CITY OF ALBUQUERQUE

July 13, 2021

**RE: Lot 15 Block 6 Volcano Cliffs Unit 18 SAD 228
6516 Kimmick Dr. NW
Grading and Drainage Plan
Engineers Stamp Date: 4/12/2021 (D10D003M15)
CO Certification Date: 7/12/2021**

PROJECT NAME:		
SHEET TITLE:		
SUBMITTED FOR:	SHEET NUMBER:	
<div style="text-align: center;"> <h1>VOLCANO CLIFFS</h1> <h1>6516 KIMMICK DR NW</h1> <h1>PULTE ID 13</h1> <h2>GRADING AND DRAINAGE PLAN</h2> <h2>GRADING PERMIT</h2> </div>		
1 OF 1

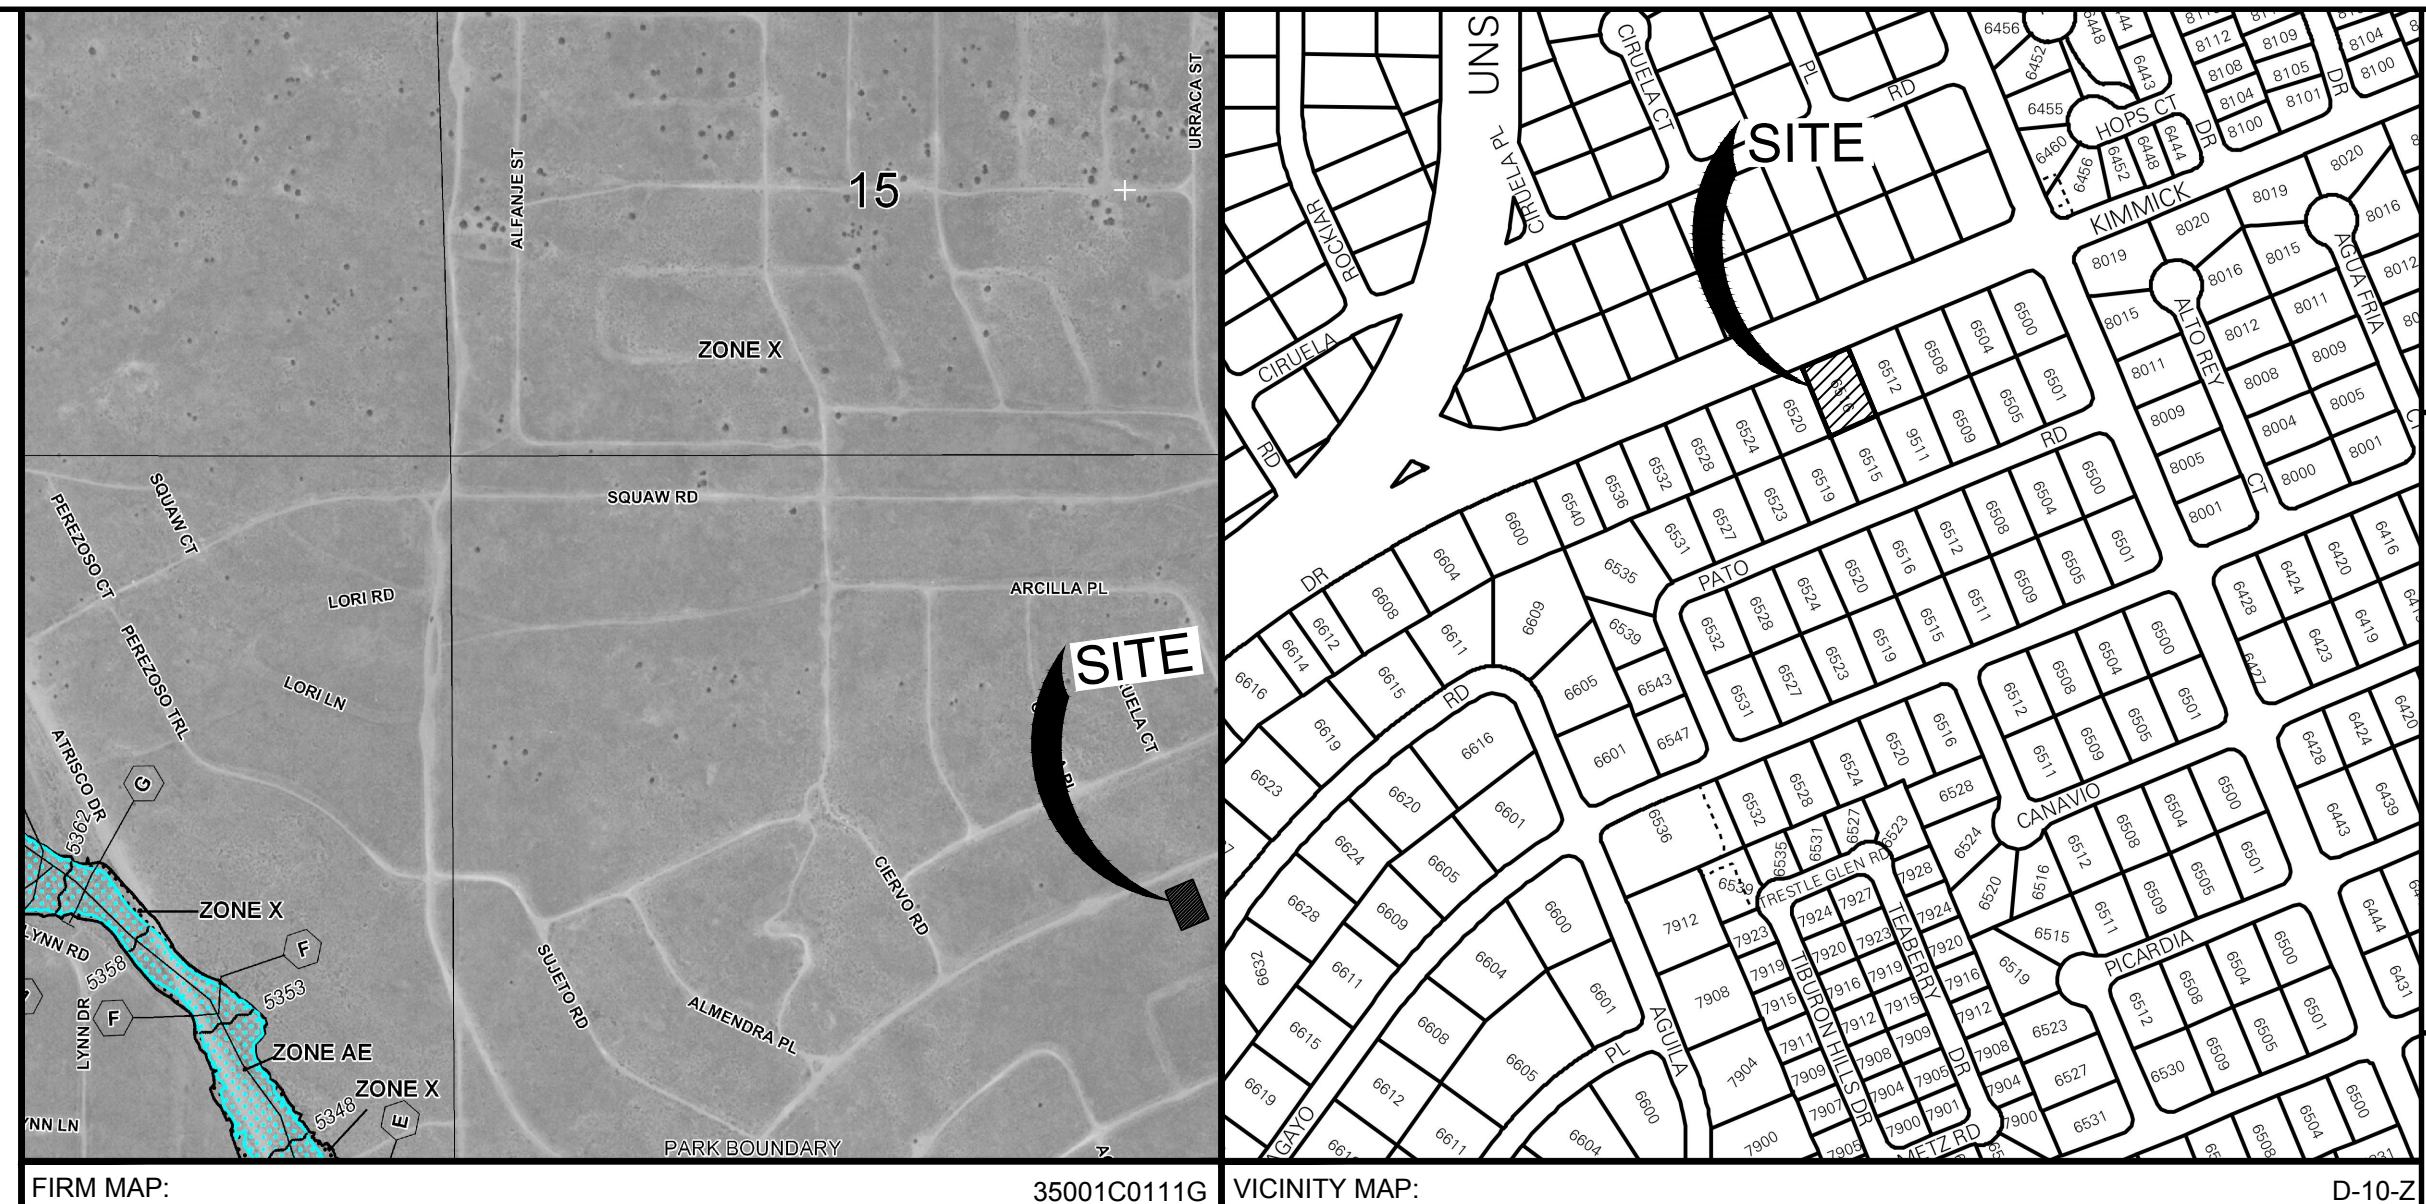
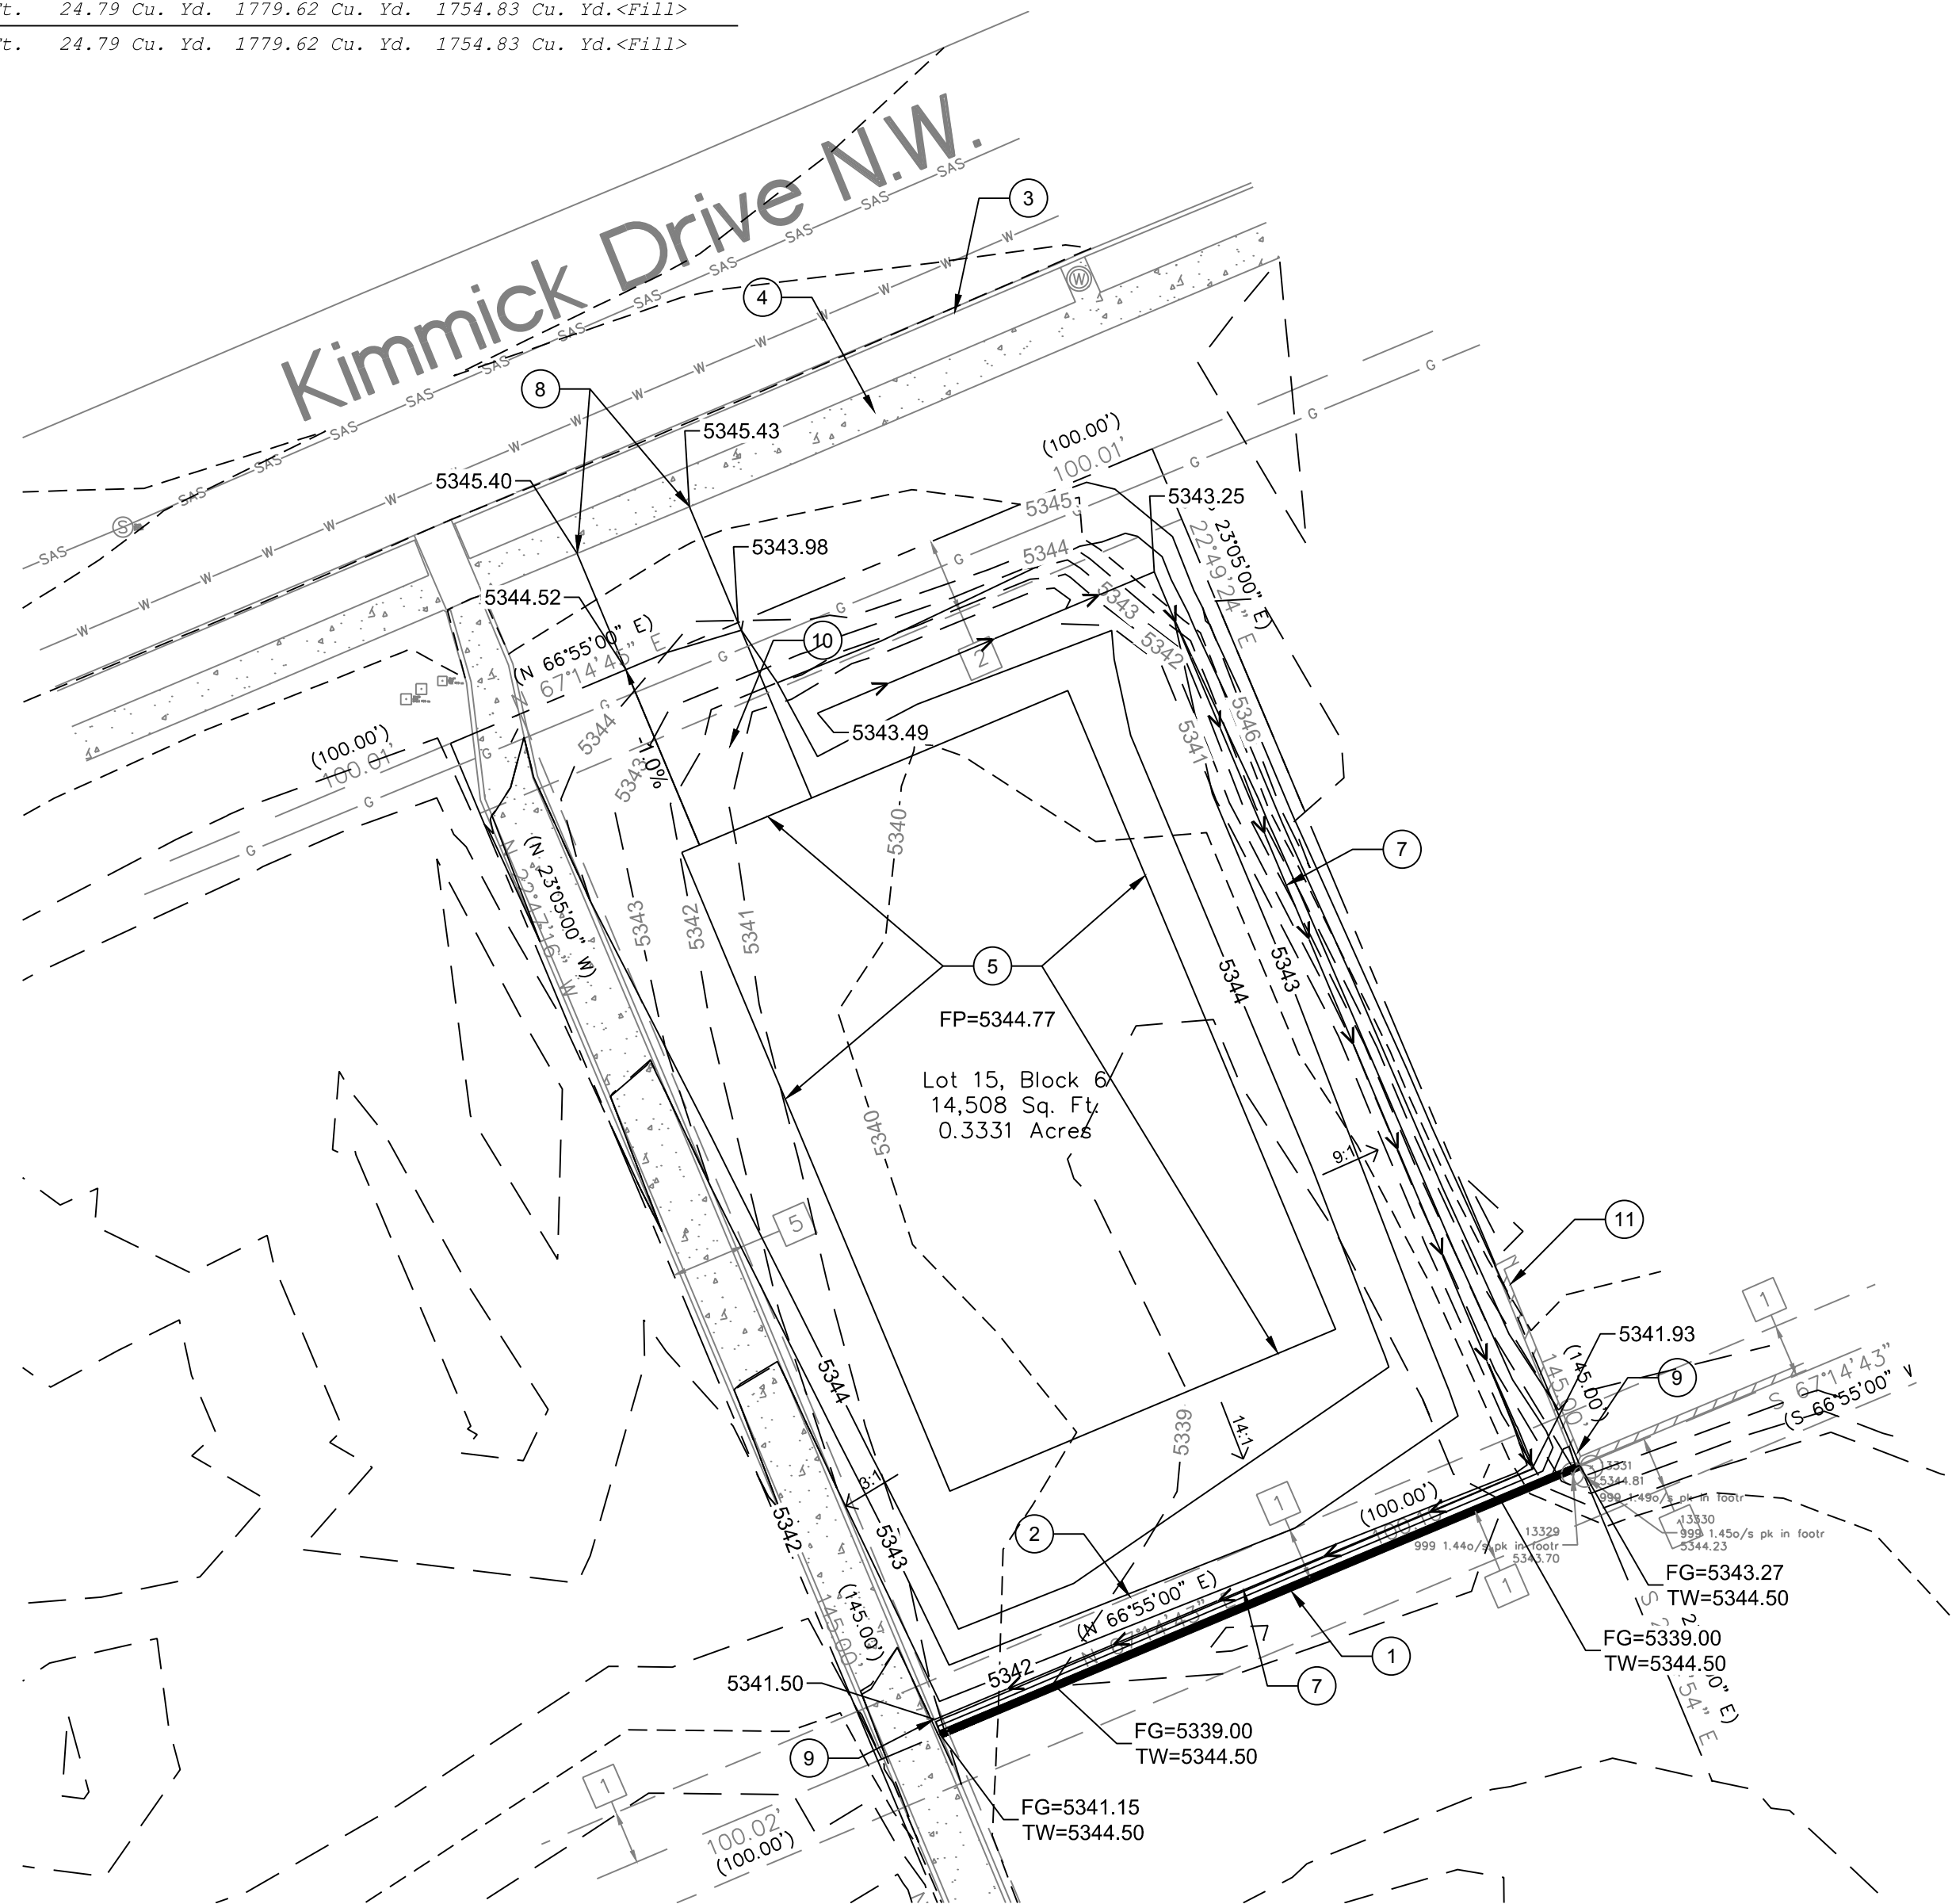
- Provide erosion control measures on the north side of lot.
- Provide how dirt and debris will be kept out of the concrete channel.
